Recommendation Report for Planning Permission**REF NO:** AB/115/17/PL**LOCATION:** Former Arundel Equine Hospital
Tortington Lane
Arundel**PROPOSAL:** Erection of 1 No. dwelling (resubmission following AB/81/16/PL). This application is a Departure from the Development Plan**SITE AND SURROUNDINGS**

drawing title:
PLOT 5 – Plans

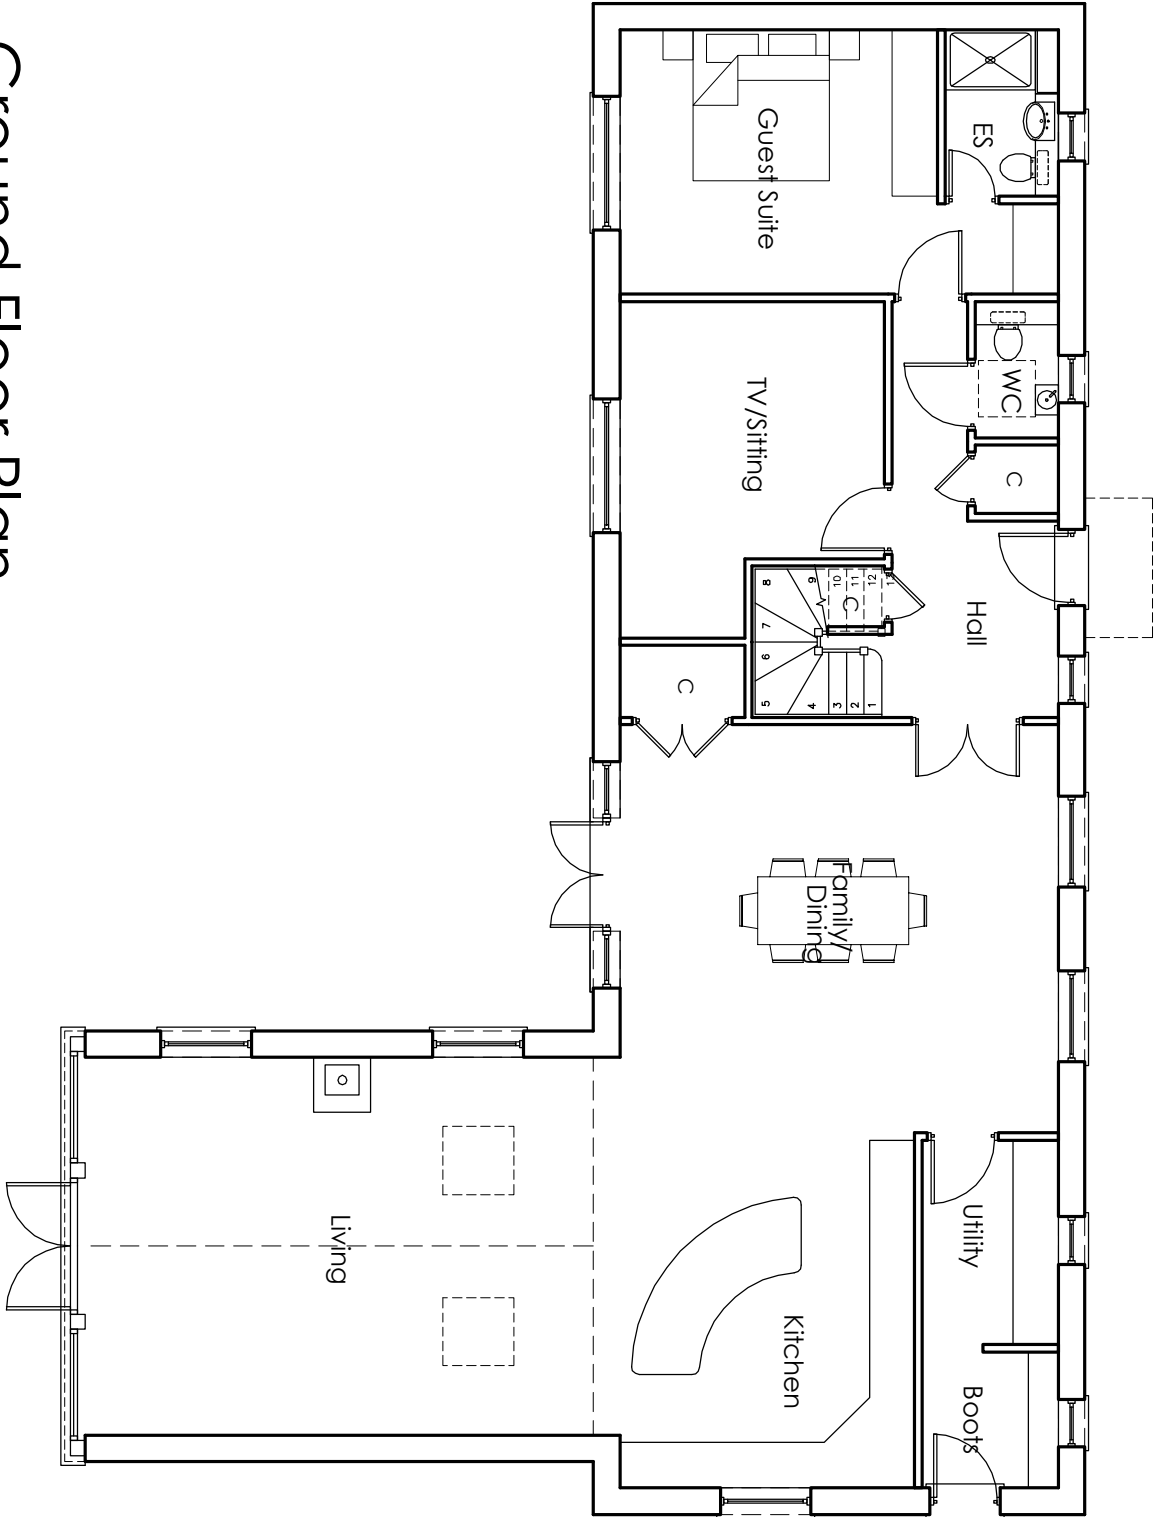
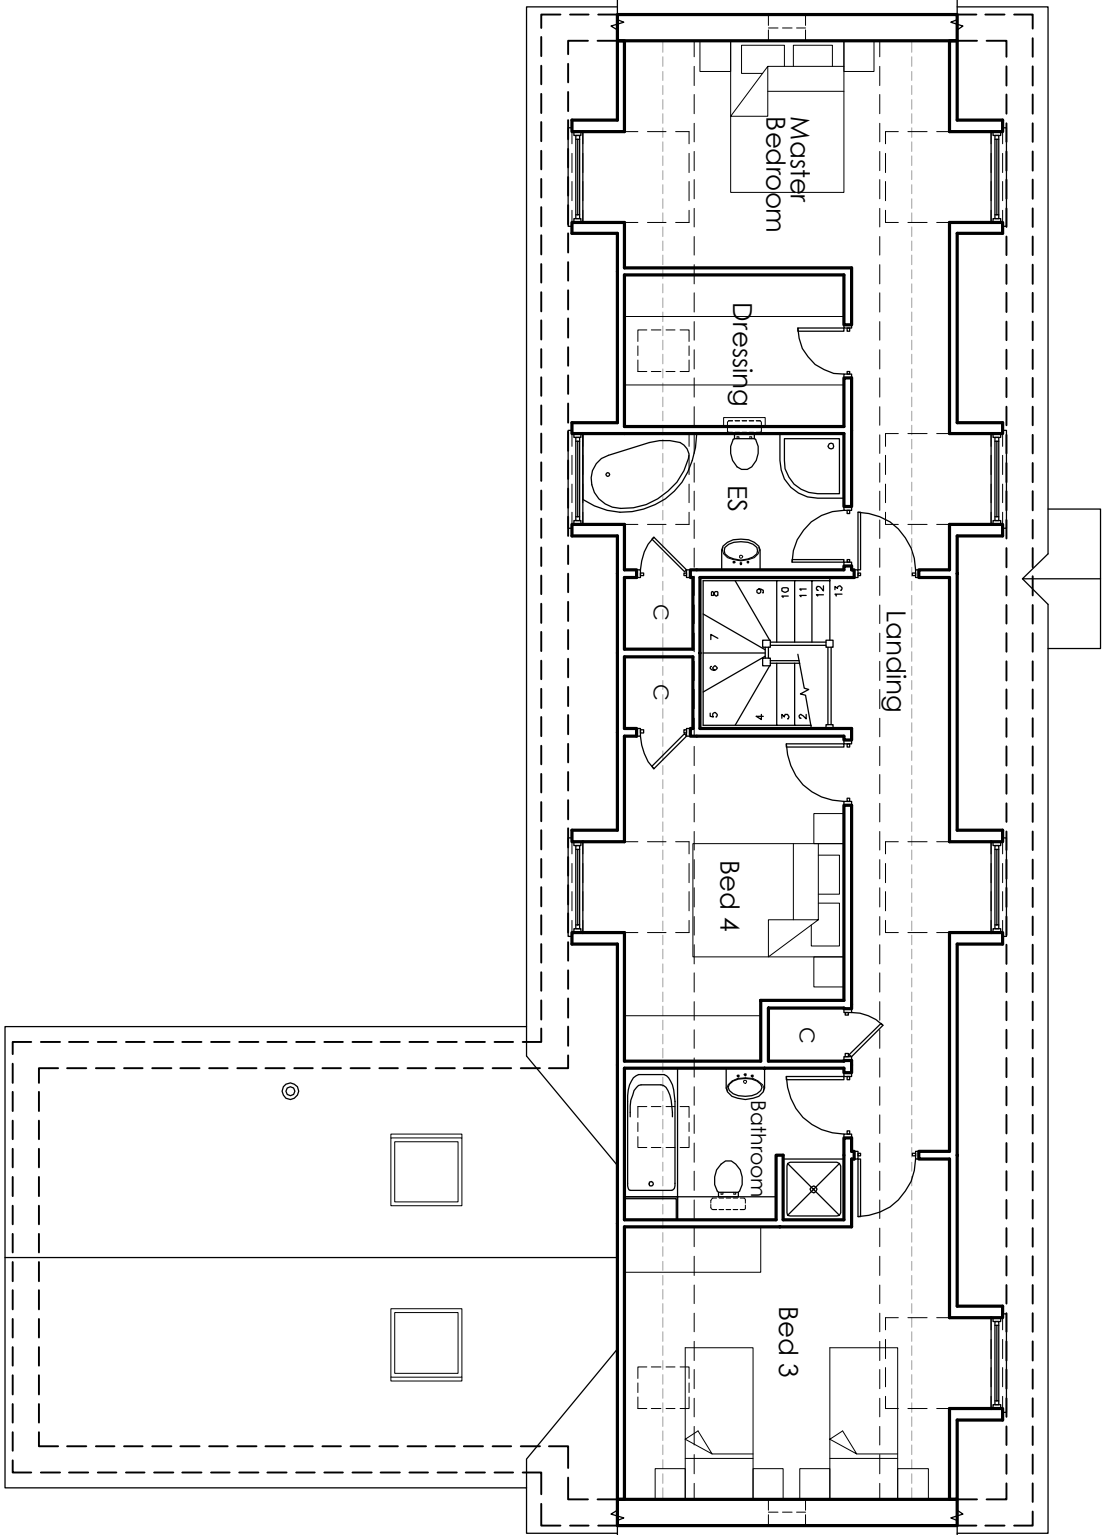
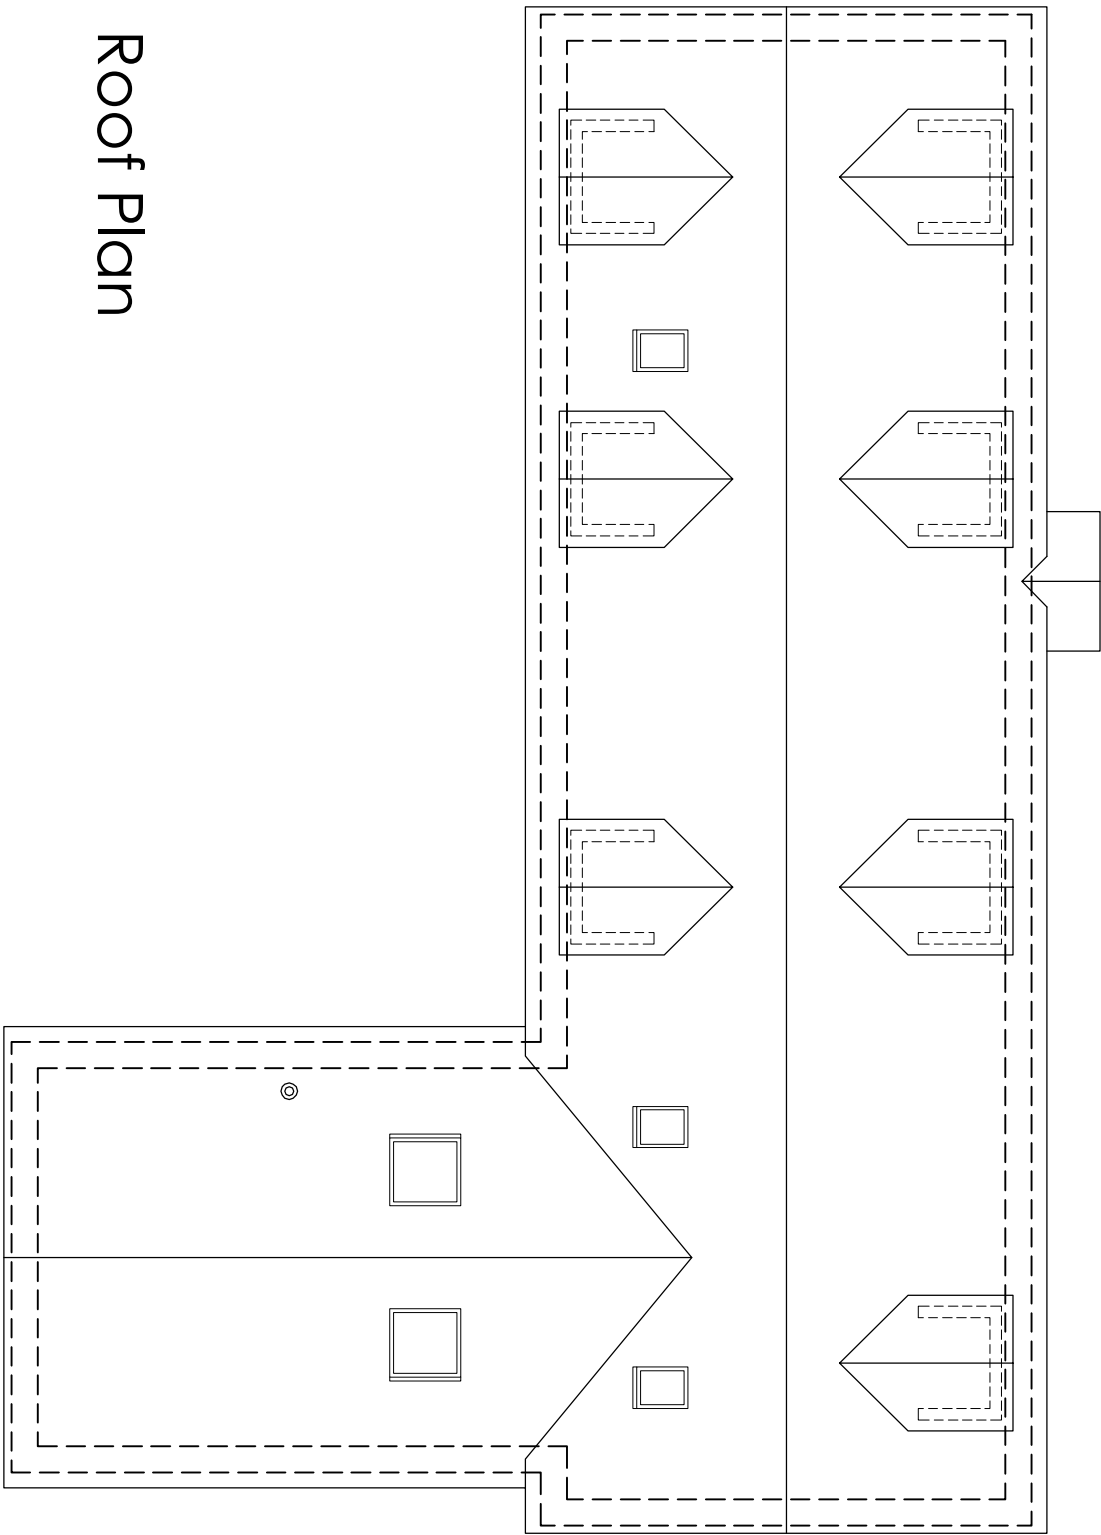
The dwelling would have one first floor window in the side elevation which could result in adverse overlooking of the adjacent recently approved dwelling, but this could be controlled by an obscure glazing.

- 3 By reason of site coverage, design and height the proposal would constitute an alien intrusion in the countryside which would be out of keeping with and detrimental to the rural character of the locality in conflict with policies GEN2, GEN3, GEN7 of the Arun District Local Plan and policies SD SP2, C SP1 and DDM1 of the publication version of the local plan October 2014 (updated March 2017) and the National Planning Policy Framework.

job number: **1781** drawing number: **P501** revision: **C**

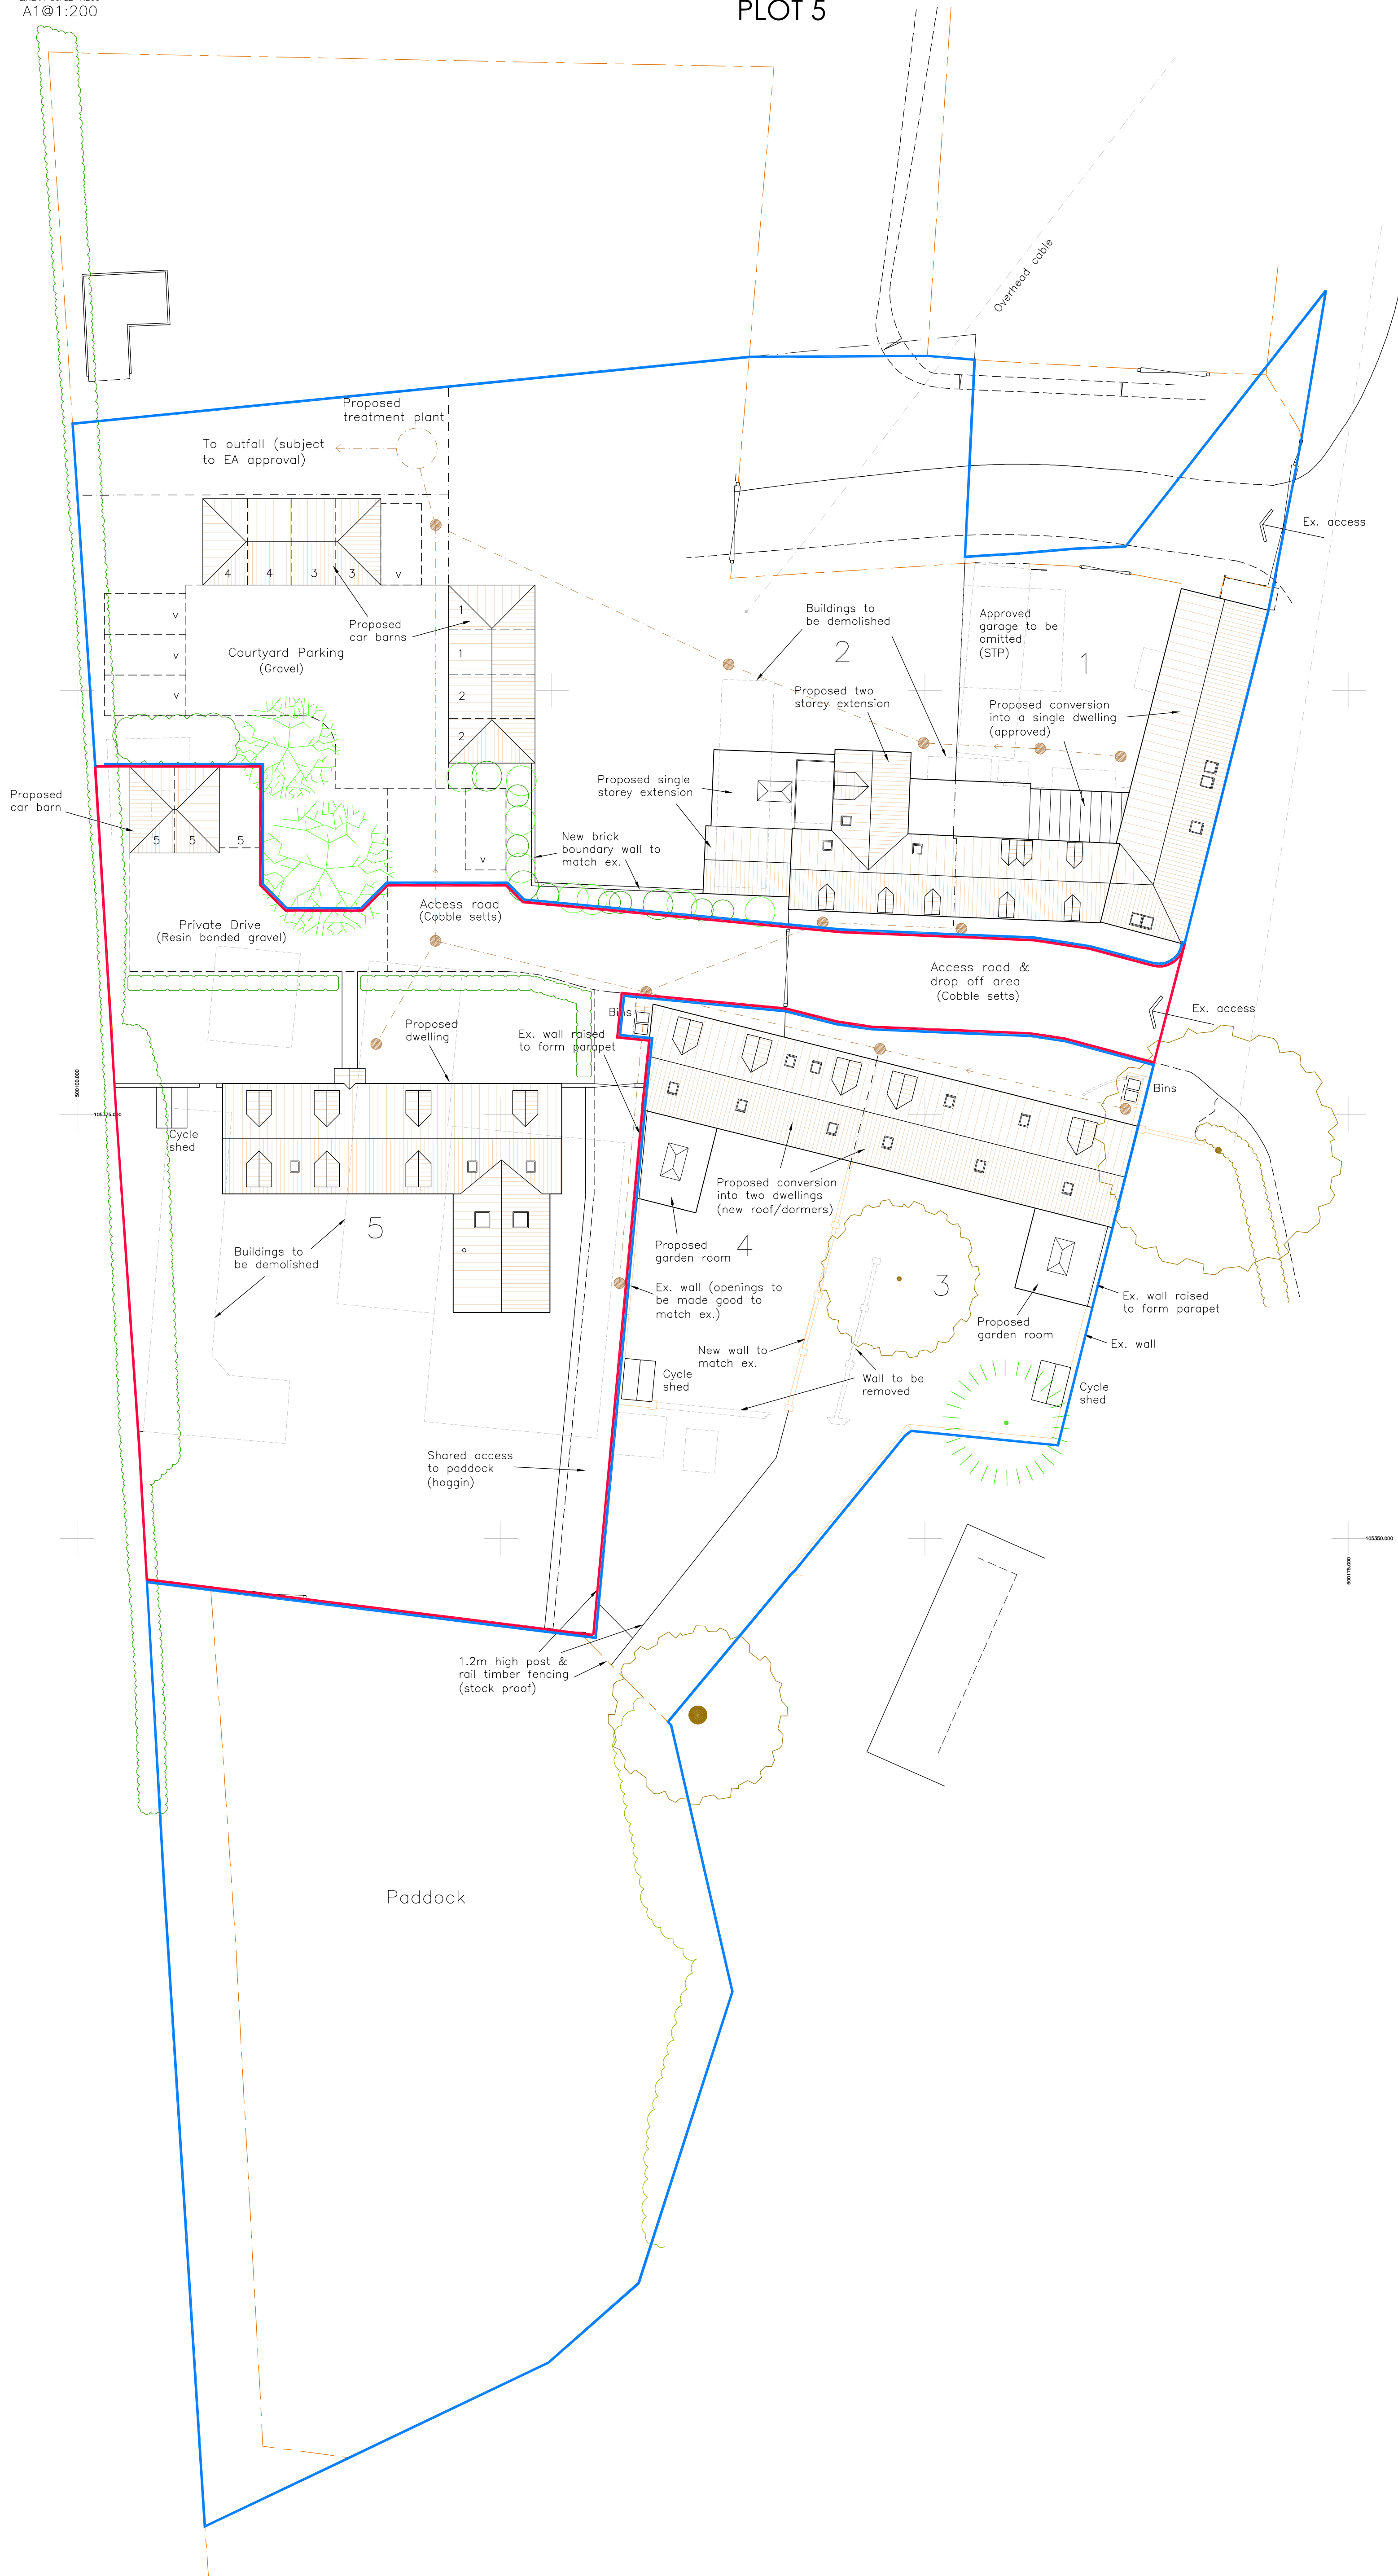
The proposal has also increased the curtilage of the application site to include additional land to the frontage for car parking. This could easily be accommodated within the previously approved residential curtilage and represents an unnecessary expansion of built form in the countryside which is contrary to policy GEN3 of Arun District Local Plan.
